**From:** Adrian D'Cruz [REDACTED]  
**Sent:** 16 August 2021 13:12  
**To:** Simon Davis  
**Subject:** RE: Planning Consultation on: AW/228/21/RES  
**Attachments:** 002 Landscape Plan REV A 16 08 21.pdf; 014 Garages 14 08 21.pdf; 001 Site Layout & Block Plan REV A 13 08 21.pdf; 003 Parking Plan REV A 13 08 21.pdf; Carlton Avenue Biodiversity Statement 110821.pdf; Tree Survey & AIA 34-44 Carlton Avenue. 01072021.pdf

**From:** Simon Davis <Simon.Davis@arun.gov.uk>  
**Sent:** 06 August 2021 16:45  
**To:** Adrian D'Cruz [REDACTED]  
**Subject:** RE: Planning Consultation on: AW/228/21/RES

**From:** Adrian D'Cruz [REDACTED]  
**Sent:** 03 August 2021 19:13  
**To:** Simon Davis <Simon.Davis@arun.gov.uk>  
**Subject:** Re: Planning Consultation on: AW/228/21/RES

CLIENT	Counterpoint Properties Ltd	
SITE	Carlton Avenue, Rose Green, West Sussex	
PROJECT	Proposed Development Comprising 8 Dwellings	
DRAWING	003 Parking Plan	
DATE	18 06 21	
AUTHOR	AH	REVISION
STATUS	PL	
SCALE	1: 500 @ A3

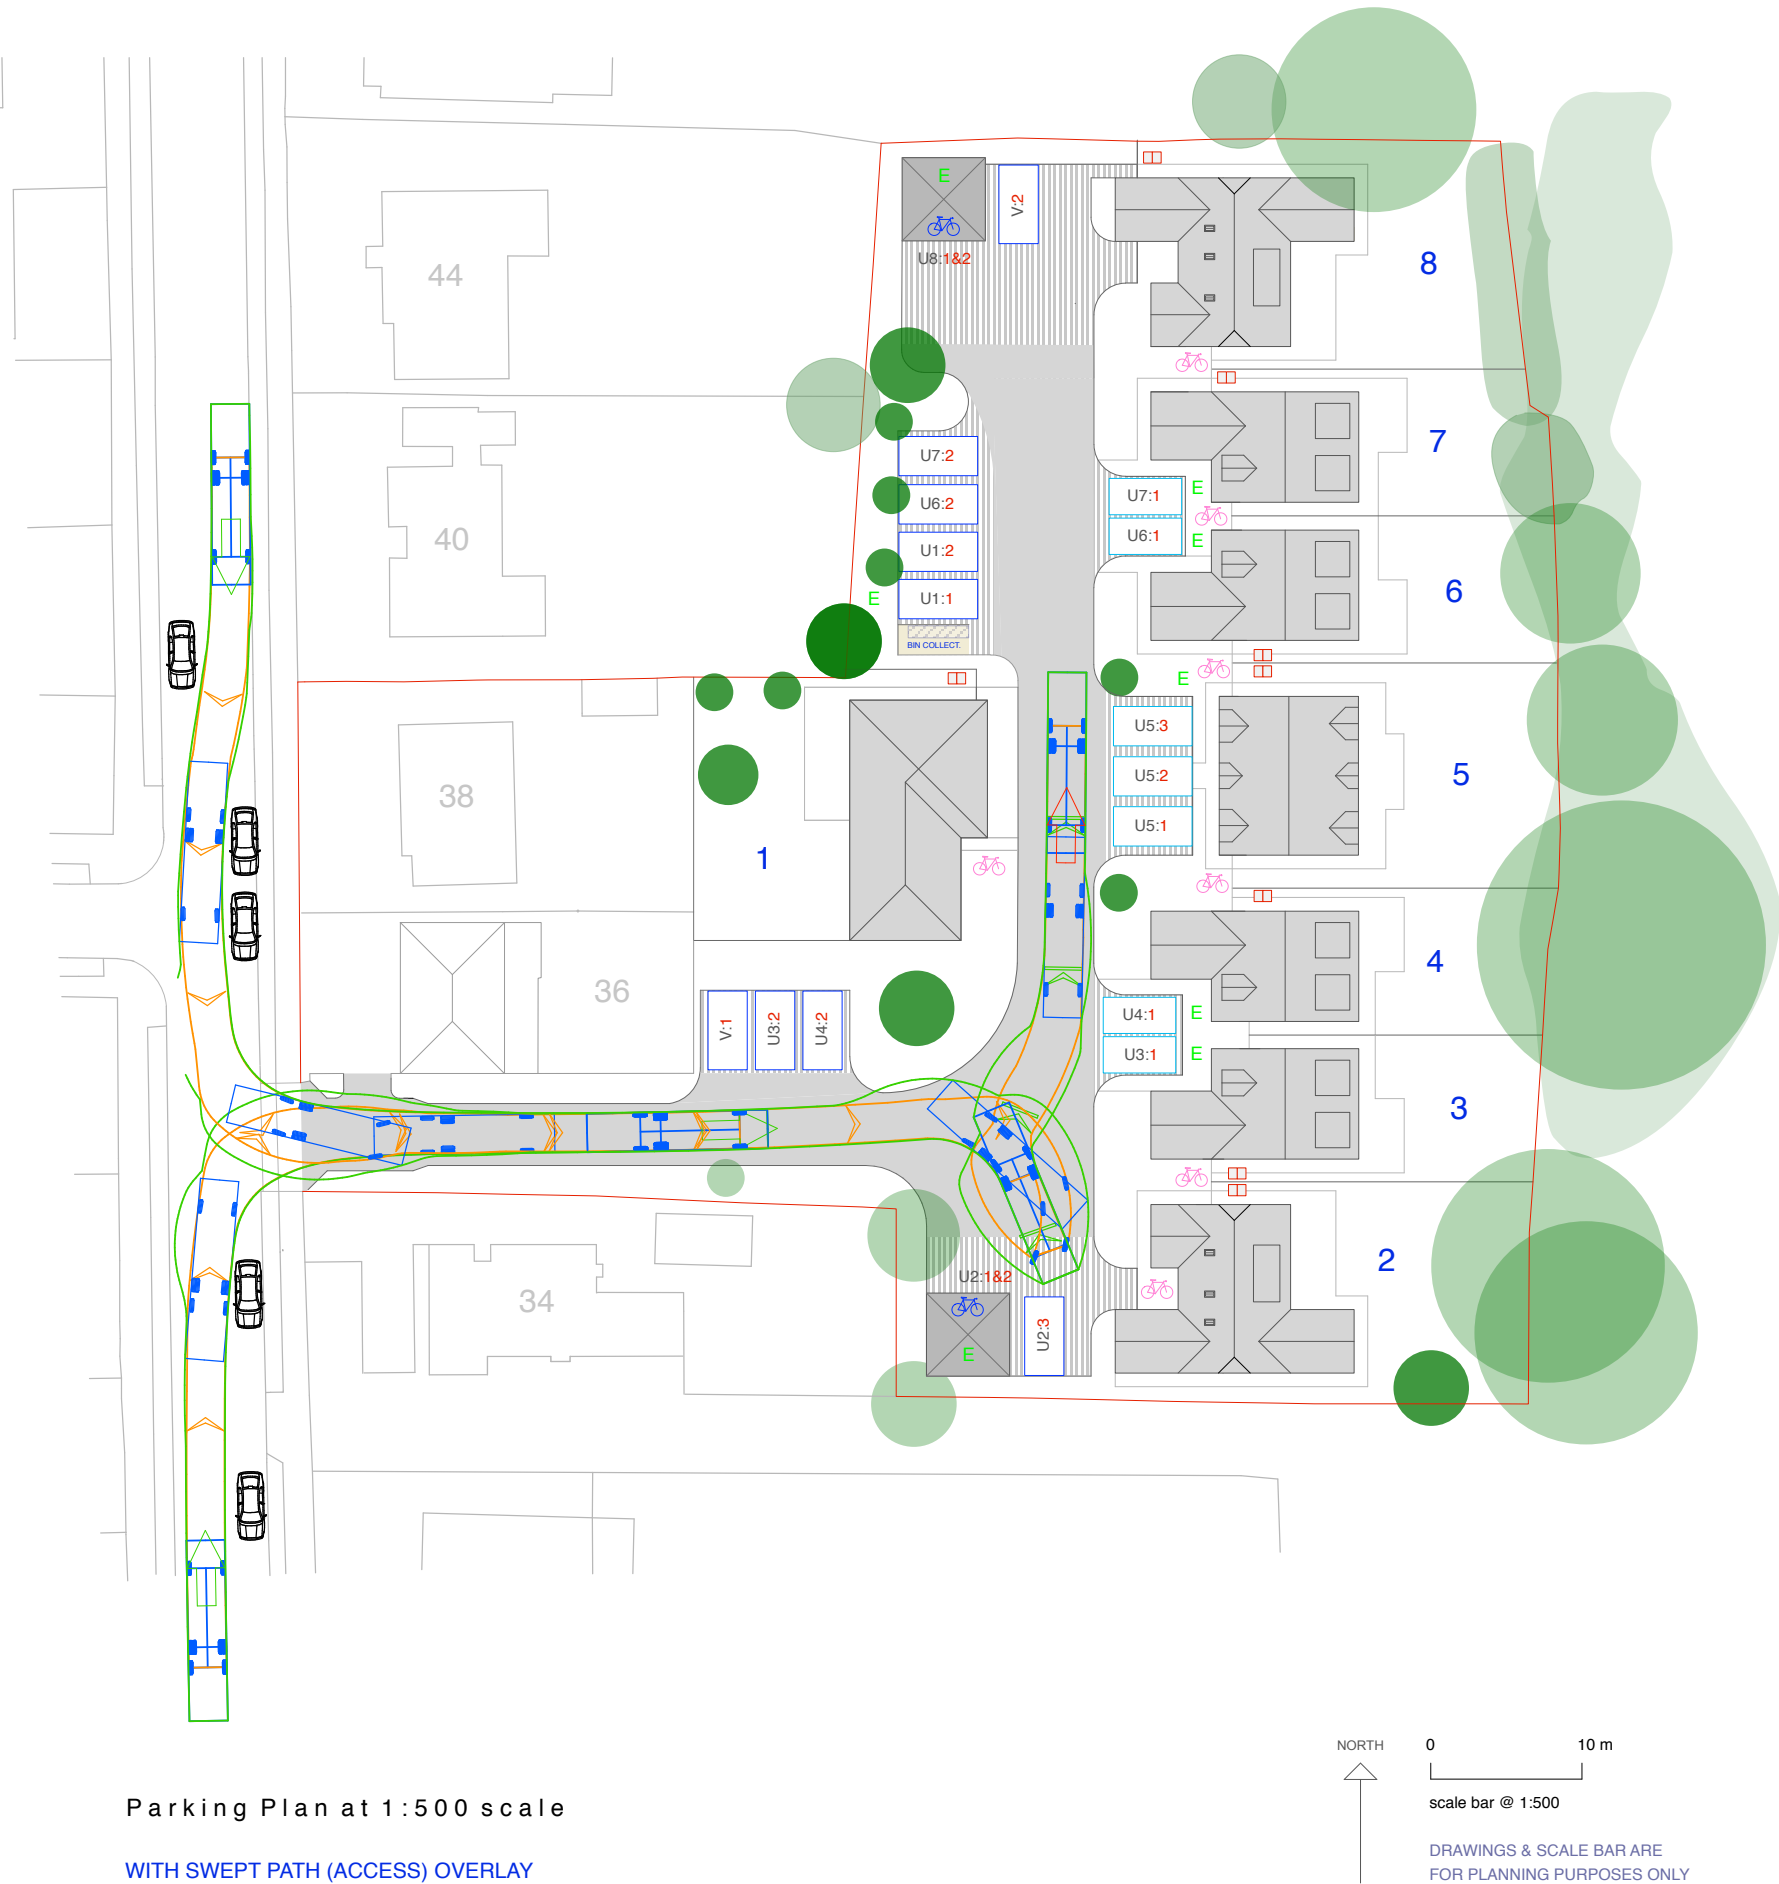
Our Parking Standards SPD requires 19 spaces including 2 visitor. You show 18 and 2 visitor but 4 of these are in double garages. The issue is that our SPD states that garage spaces must be 3 x 6m (single) to be counted as half a space and that if not meeting these dimensions they will not be counted at all. There are no floor or elevation plans for the garages (this itself is an issue) but I measured from the layout plan and the garages seem to be 5.5m by 5.5m so are undersized. As each garage only serves one dwelling, I will count them as providing half a space each but this leaves you short by 2 spaces versus the requirements.

If you increase the garage dimensions to 6m by 6m then I can treat them as having 1 space each (2 x 0.5 each) but this still leaves you short of the requirements. Therefore, I suggest that you change the garages for double car ports as that way I can treat them as having 2 spaces each. If you agree, then I will need plans & elevations of the car ports. If you also need to amend the dimensions of the structure then I will also need other plans amending to show this (layout, landscaping, parking plans).

The Parking Plan has been amended to include smaller double garages (but well in excess of 6x3m internally) so we have accounted each as 0.5 spaces. Due to the smaller dimensions an additional uncovered parking space is created at the southern end of the site so a total of 19 spaces (as per the calculation methodology) is provided as required.
